DECISION DELEGATED TO HEAD OF PLANNING

Application No: H16-0882-25 **Applicant:** Robert Doughty
Consultancy Limited

Proposal: Change of use from a single dwelling to dental surgery including alterations, additional gravel parking, improvements to existing access and plant shed

Location: 65 Holbeach Road Spalding

Proposed West Elevation 1:100

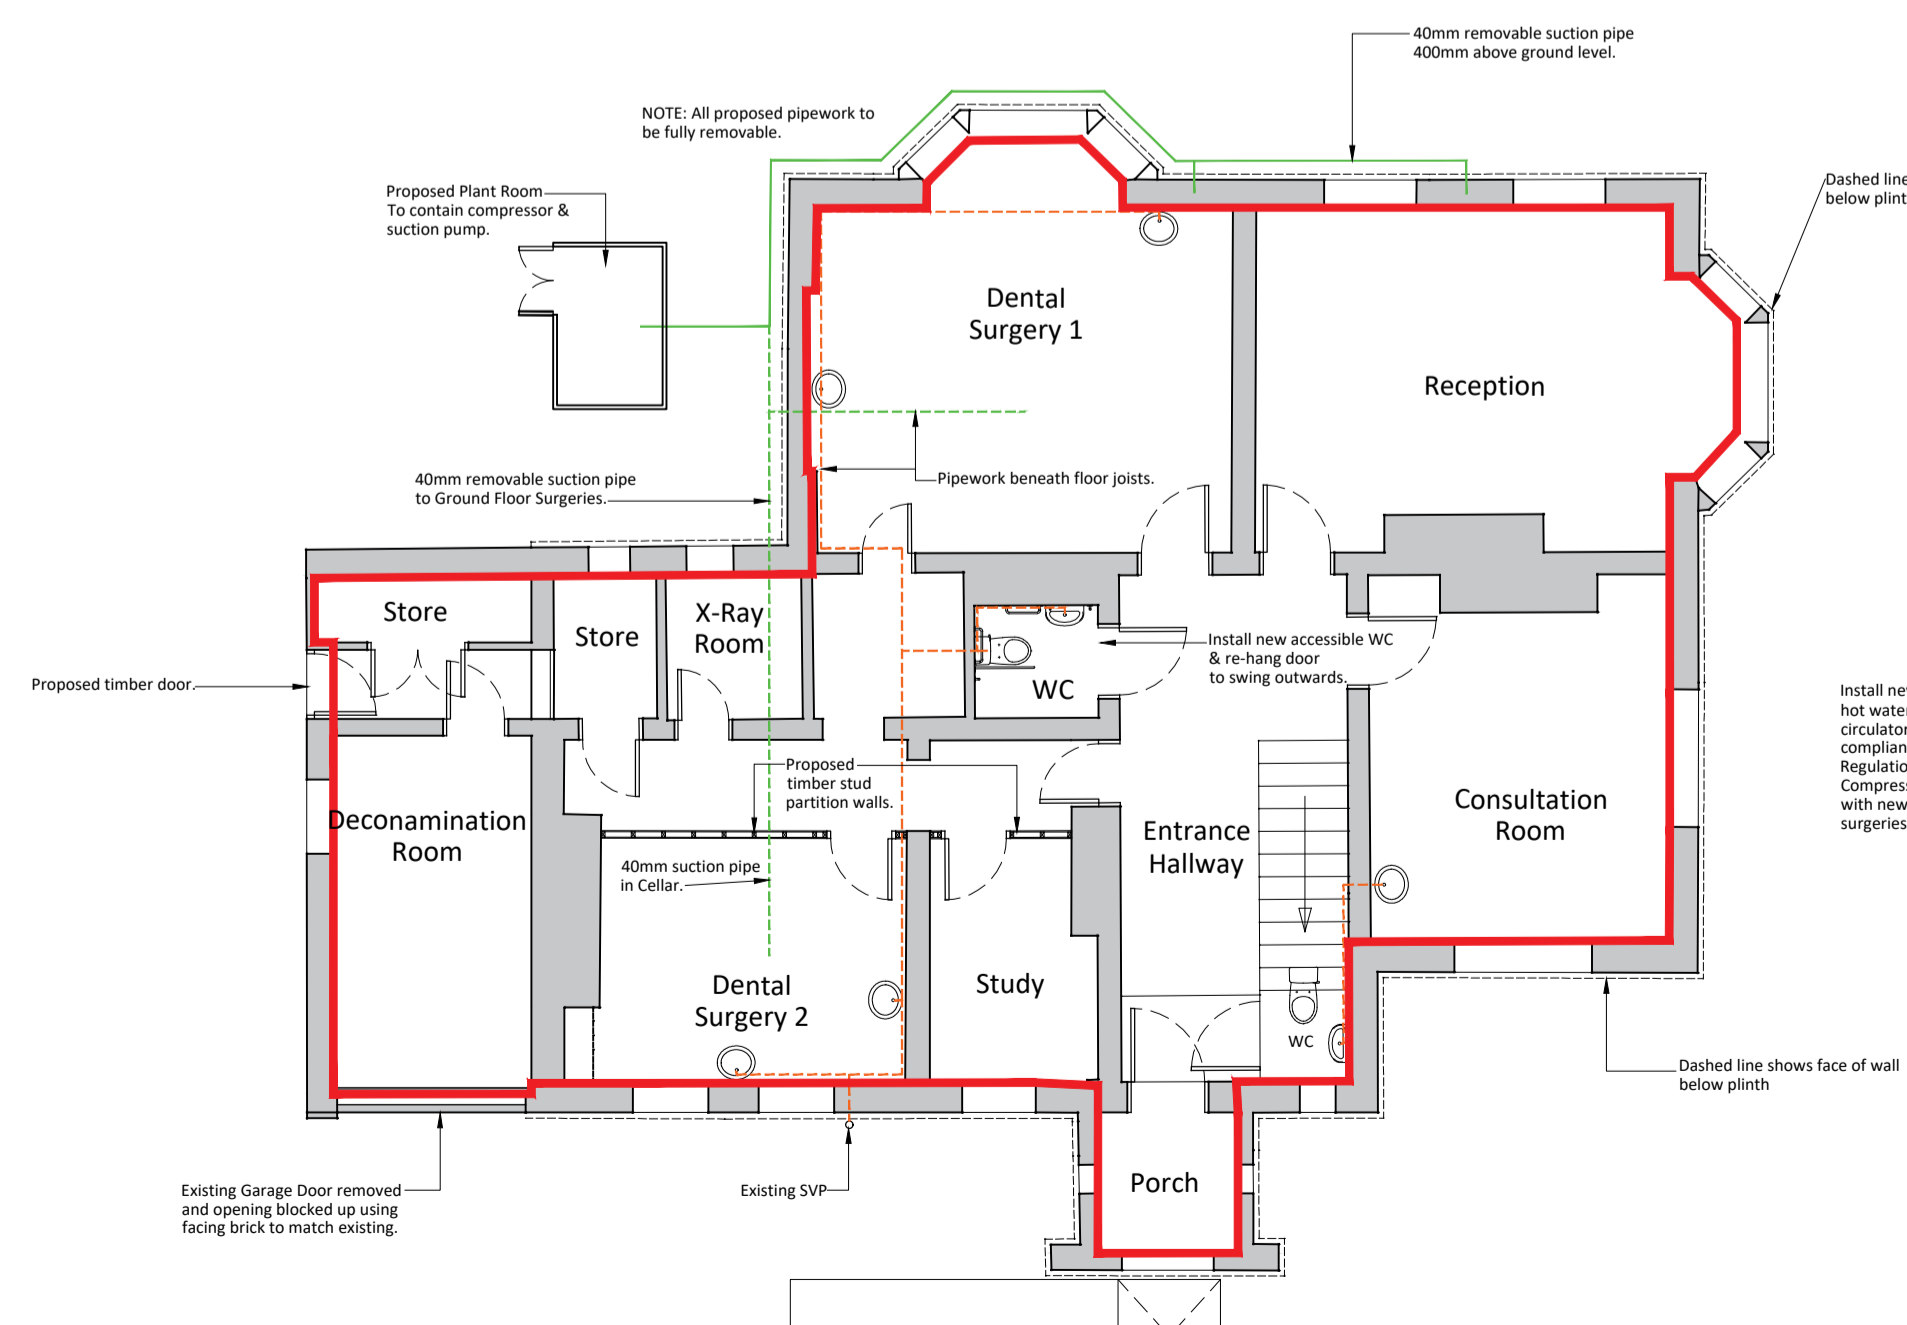
Exterior alterations include the bricking up of existing garage door opening, the erection of a small plant room lean-to in timber on the rear elevation, as well as the reformatting of the driveway and a portion of the front garden for use as a car park for customers.

Regarding external works; the most major shall be the bricking up of the garage door. There is no value inherent to this portion of the building being used as a garage, and the extant doors appear to be a mid-late C20th affectation. The proposed lean-to is quite modest and features only to rear and lesser elevations. Alterations to the driveway are relatively minor, and do not strip character from the garden setting of the site.

I am therefore satisfied that this application may be approved subject to conditions which require brickwork and mortar to match the existing, and which requires the removal of the proposed timber lean-to and making-good of associated surfaces should the site cease operation as a dental surgery, unless otherwise agreed in writing by the LPA."

Proposed Ground Floor Layout 1:100

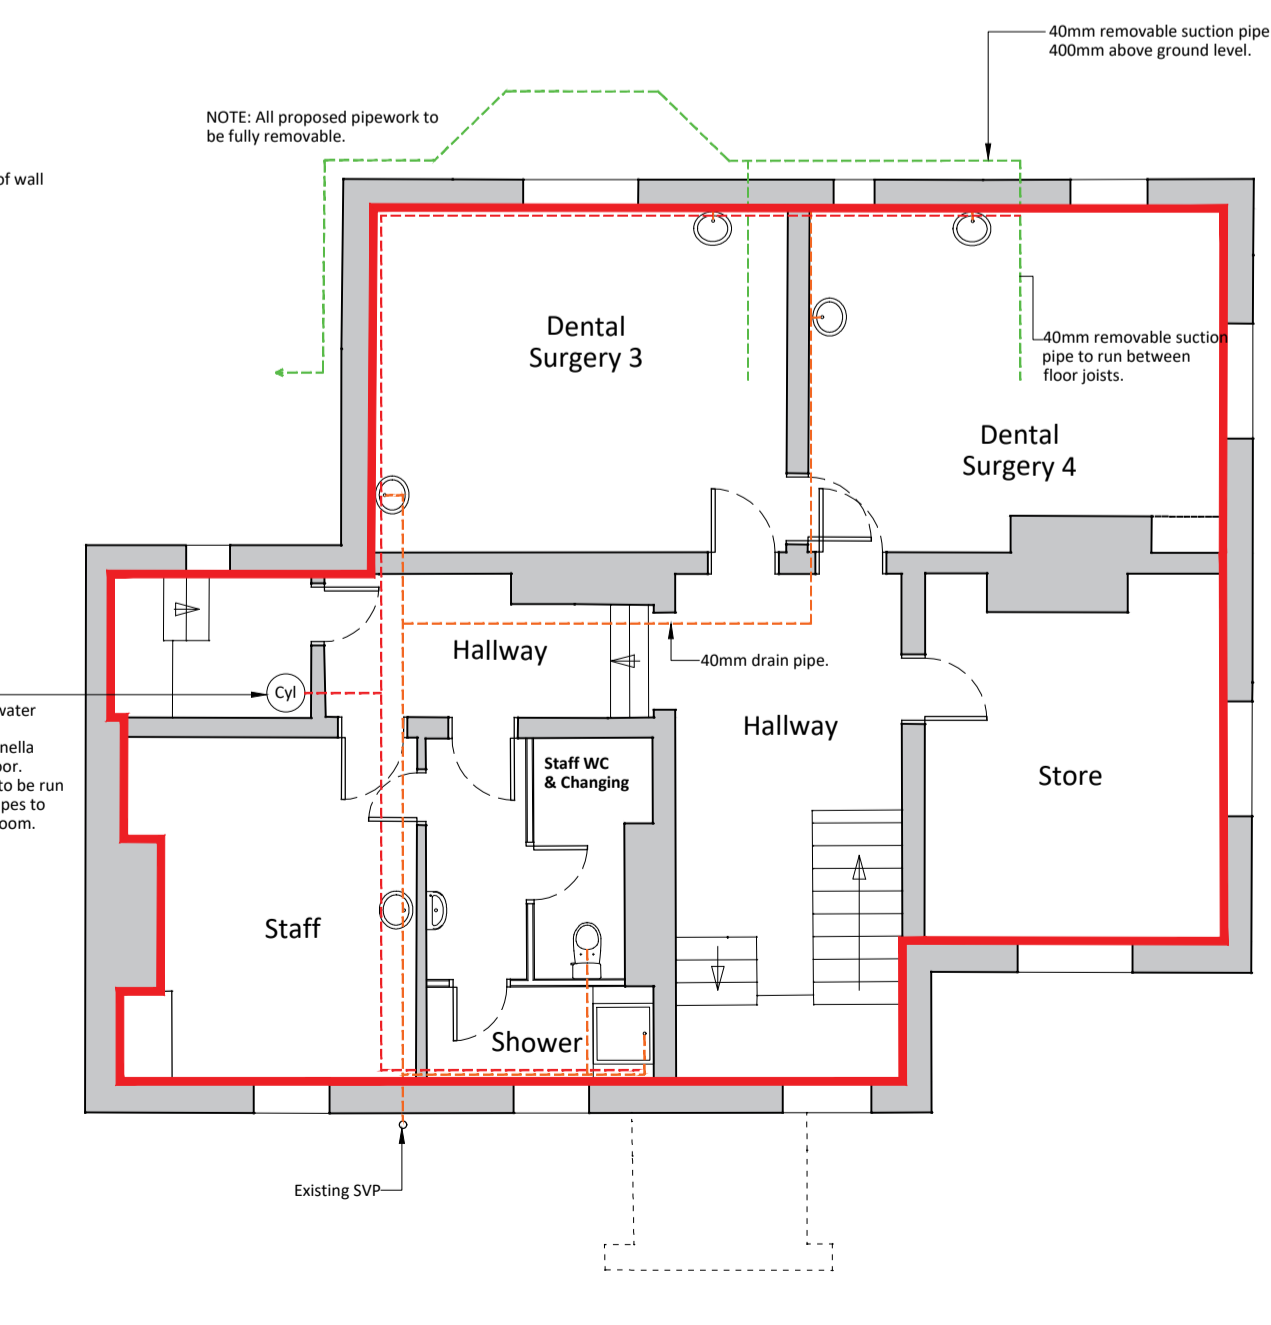
Internally a stud wall is proposed within the existing kitchen to create a dental surgery and corridor. This stud wall would be removeable. An additional door to an existing downstairs WC would be re-hung so that it opens outwards. Studwork would be installed in the first-floor bathroom to provide better welfare facilities for staff.

"I write to confirm that I have no objections on built heritage conservation grounds to this proposal. The proposed conversion of this site to use as a dental surgery seeks only extremely minor internal alterations, inclusive of a small amount of additional subdivision of ground floor rooms and 1st floor bathroom using reversible stud walling, the routing of new utilities (namely air, drainage and hot water) from external plant to further rooms, which requires only minor incision into walls, and is proposed as fully reversible.

None of the proposed alterations risk undue or unjustified harm to the special interest in the listed building. The proposed new subdivisions internally should not remove readability of the original layout and are quite minor in scale, as well as being easily reversible. The proposed utility works bear a negligible impact upon the asset.
